City of Albuquerque Stormwater Construction Site Inspection Report

ESC File No.	J10E048	Project Name:	FedEx Stockpile - Tract D
NPDES Id. No.	NMR1002UH	Location:	Fortuna Rd. NW
2/28/2022	Owner	Contractor	
Operator	Yankee Fans, LLC.	Franklins	
Contact name & title	Angelo Brunacini	John Ellis	
e-mail	abrunacini@brunacini.com	John.Ellis@feinm.com	
Contact Phone #	505-991-2233	505-975-2878	
COA Inspector	Doug Hughes	Start/End Time:	3pm
Construction Phase:	Stabilization		
Type of Inspection:	<input checked="" type="checkbox"/> Regular	<input type="checkbox"/> Storm Event	<input type="checkbox"/> Past Storm Event >0.25"
		<input type="checkbox"/> 311/Complaint	<input type="checkbox"/> Follow Up
Weather at time of inspection?	clear	Temperature: ~	60
Estimated date of last storm 0.25" or greater	1/1/2022

TRACT D MERIDIAN BUSINESS PARK ALBUQUERQUE, NM 87121	DRAWN BY pm
	STOCKPILE PLAN	DATE 3-12-2020
	TERRA WEST, LLC 5571 MIDWAY PARK PL NE ALBUQUERQUE, NEW MEXICO 87109 (505) 858-3100 www.tierrawestllc.com	DRAWING
		SHEET # ST-1
		JOB # 2019025

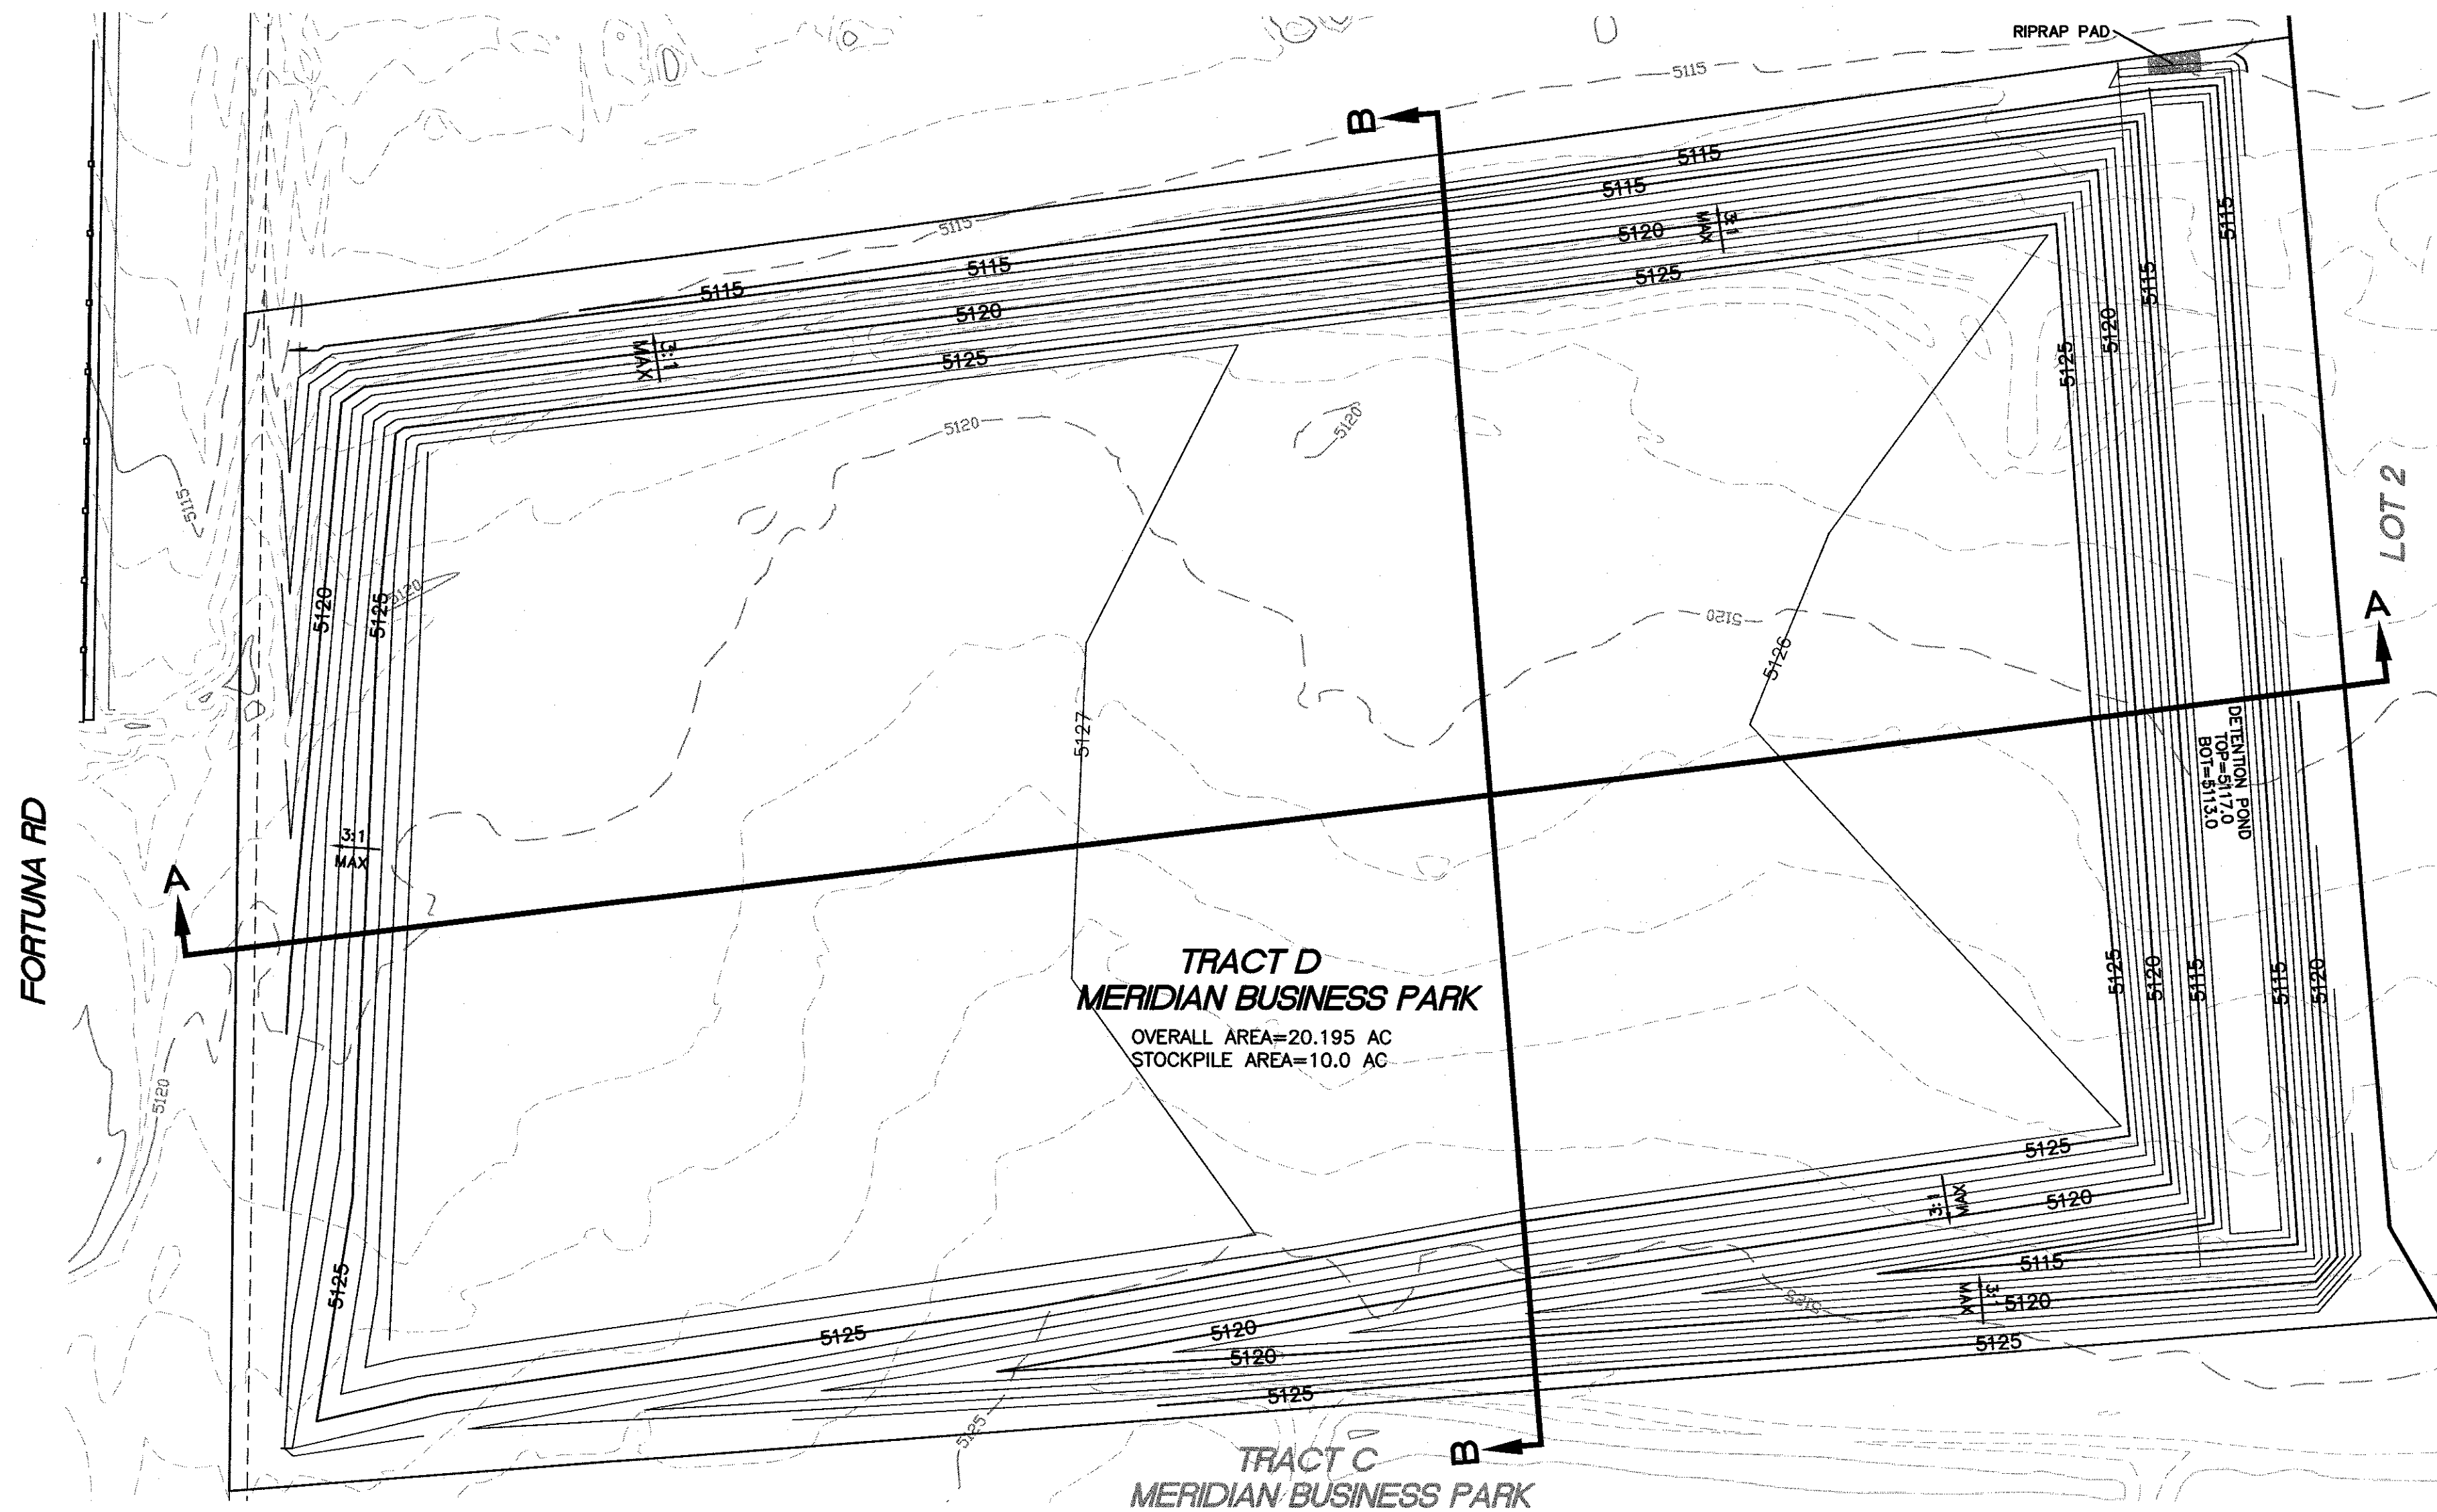
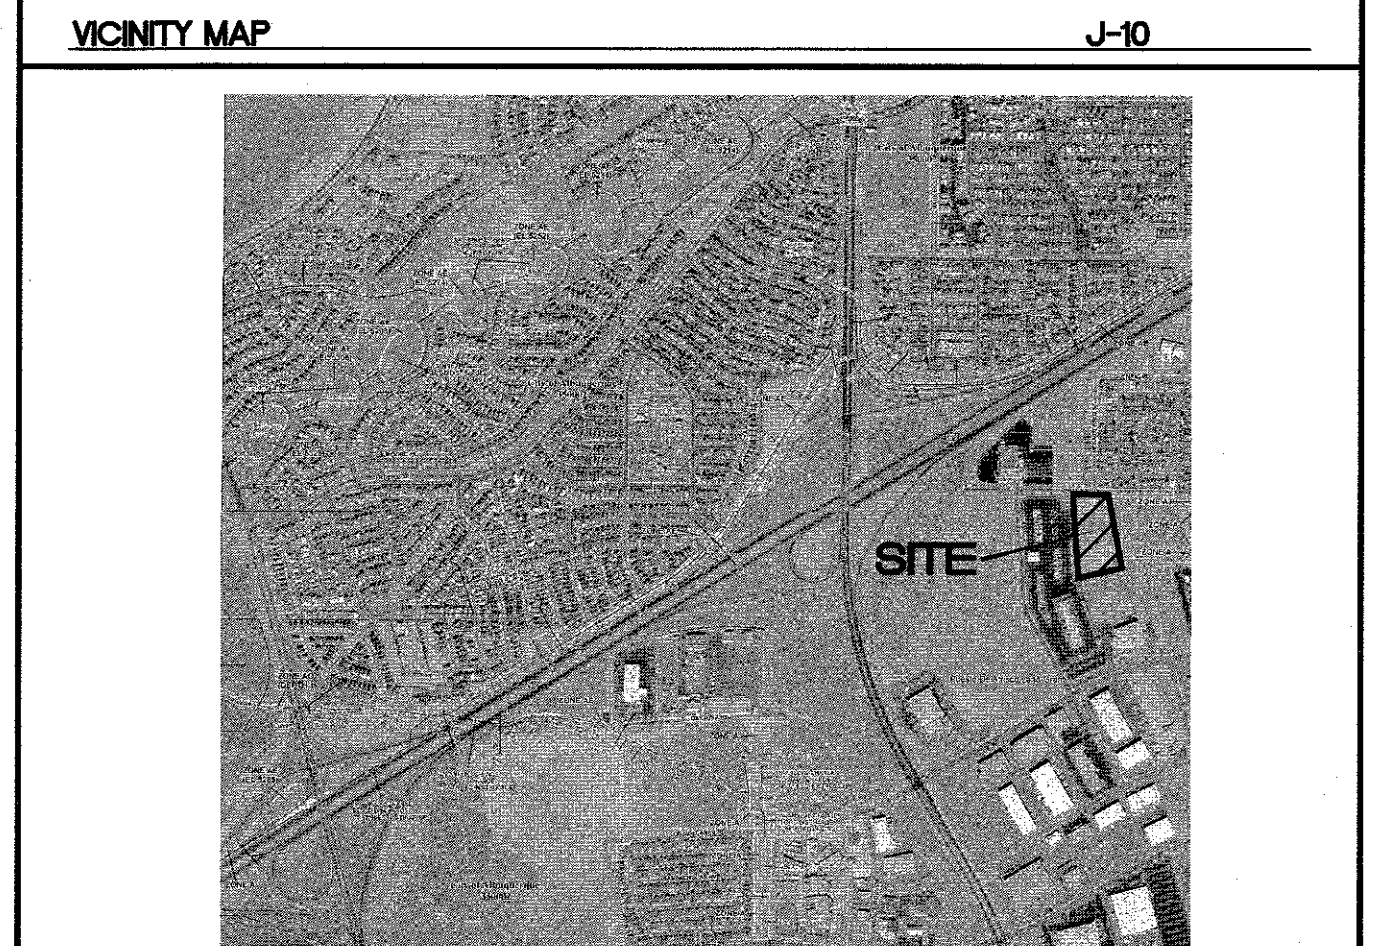
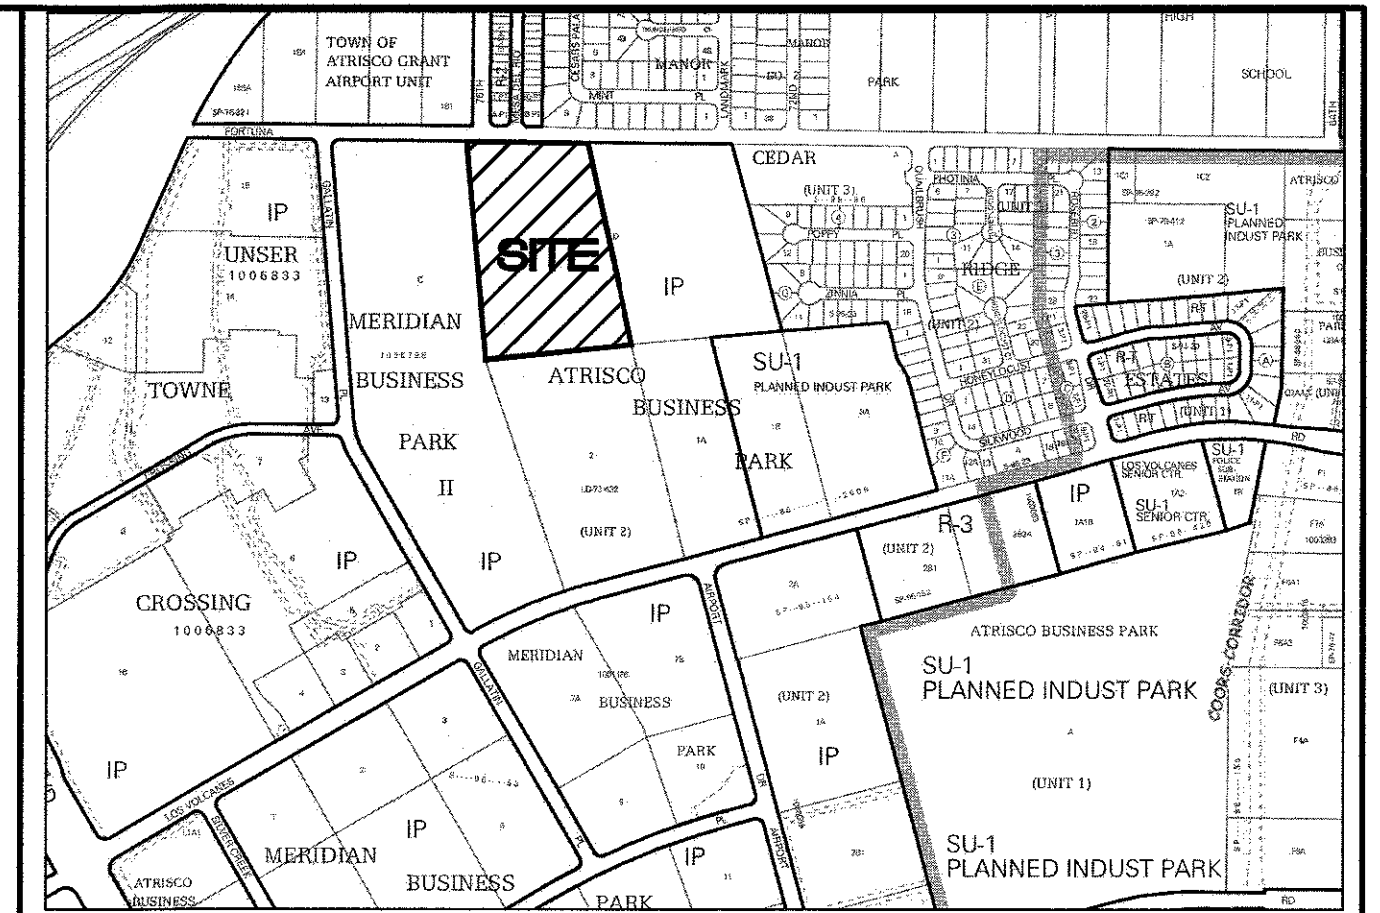
Item Number	Deficiency/ Corrective Action		
1	Silt fence missing along north side. Excess sediment accumulation south side. Repair/maintain silt fences.		
2	Site is not stabilized. Implement stabilization controls per CGP 2.2.14. Offsite area south of site disturbed by this project is full of tumble weeds that exceed the 4" max height and width but no perinial vegetation (final stabelization criteria not met and weed ordinance violation in disturbed offsite area)		
3	Provide latest self inspection report		
4			
5			
2.1	Discharge off site? (Y/N)	no	
4	Self Inspection Reports	Requested	Latest report Date:
